Subject: Shoreline Exemption Permit, Pump Station 22 – 6223 E Mercer Way.

This is a written response to the review comments provided by the Community Planning and Development Department regarding the application for the Shoreline Exemption Permit, SHL23-005, for Pump Station 22 located at 6223 E Mercer Way.

INSTRUMENTATION
PUMP STATION 22 - PLAN

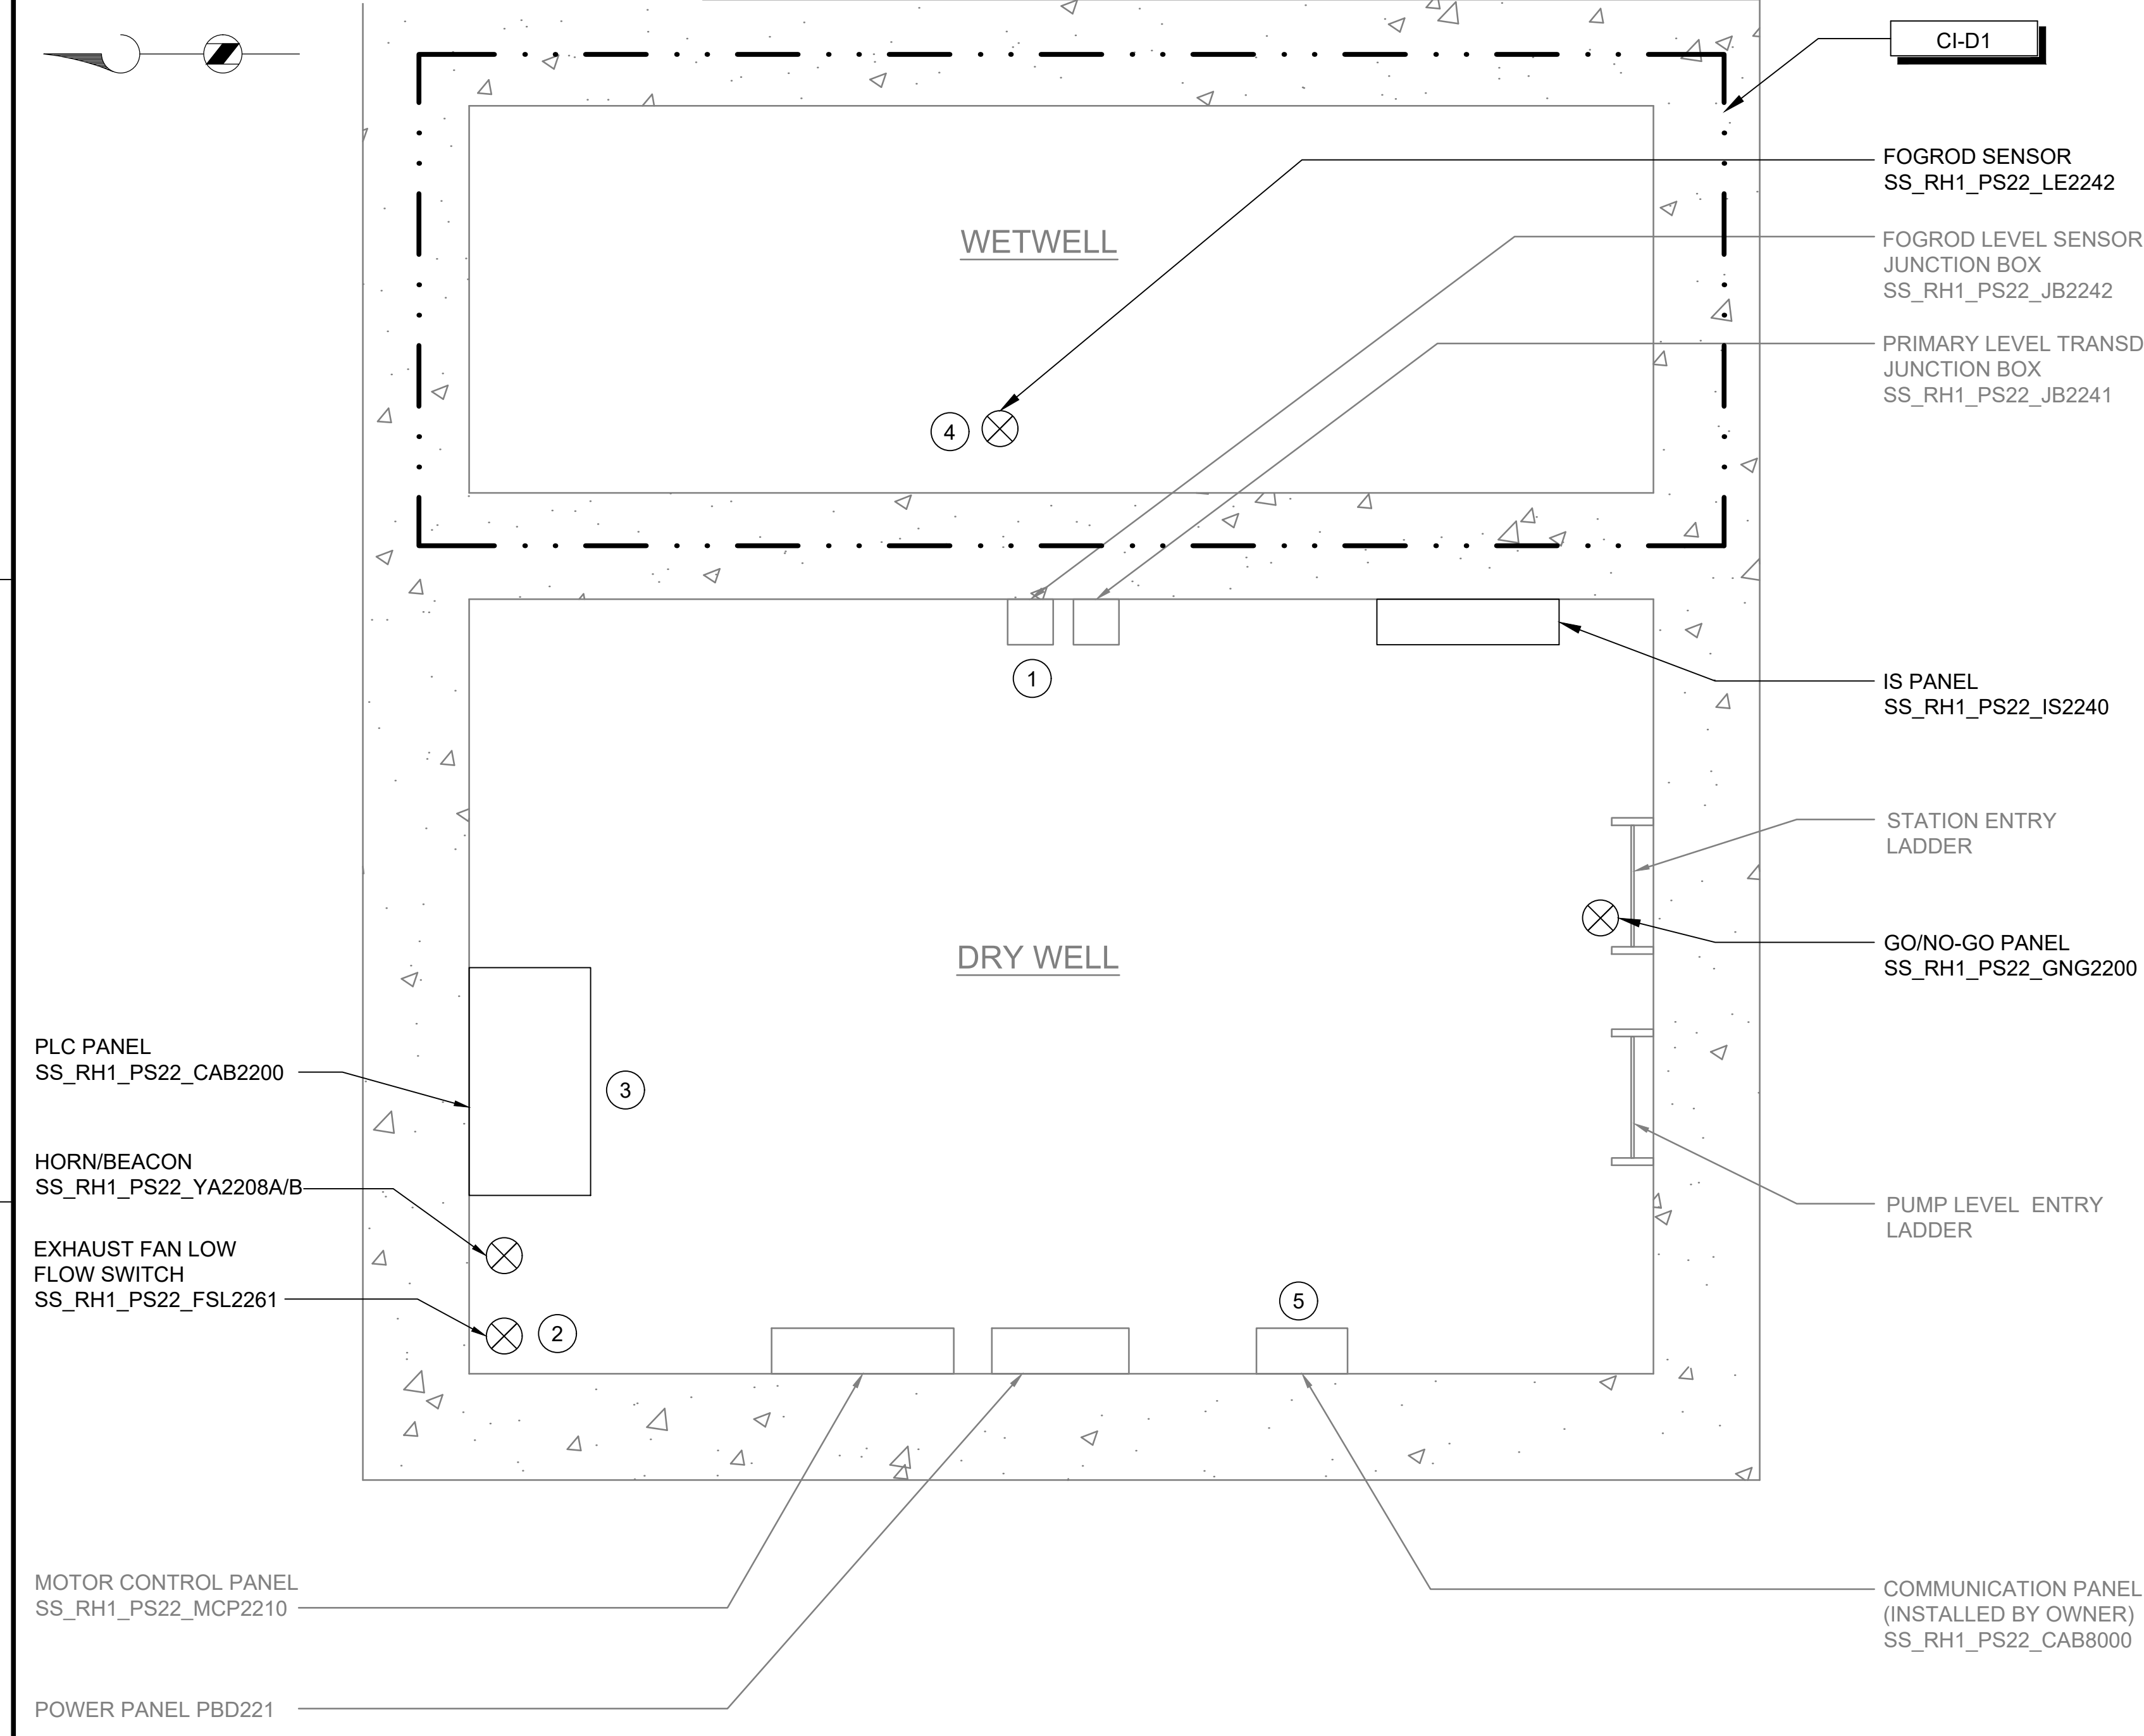
- a. Provide address of all pump stations on plans

Response: *The address for the pump station has been added to Development Plan, Instrumentation Drawing page 1. The address was also included in the aerial photo of the pump station.*
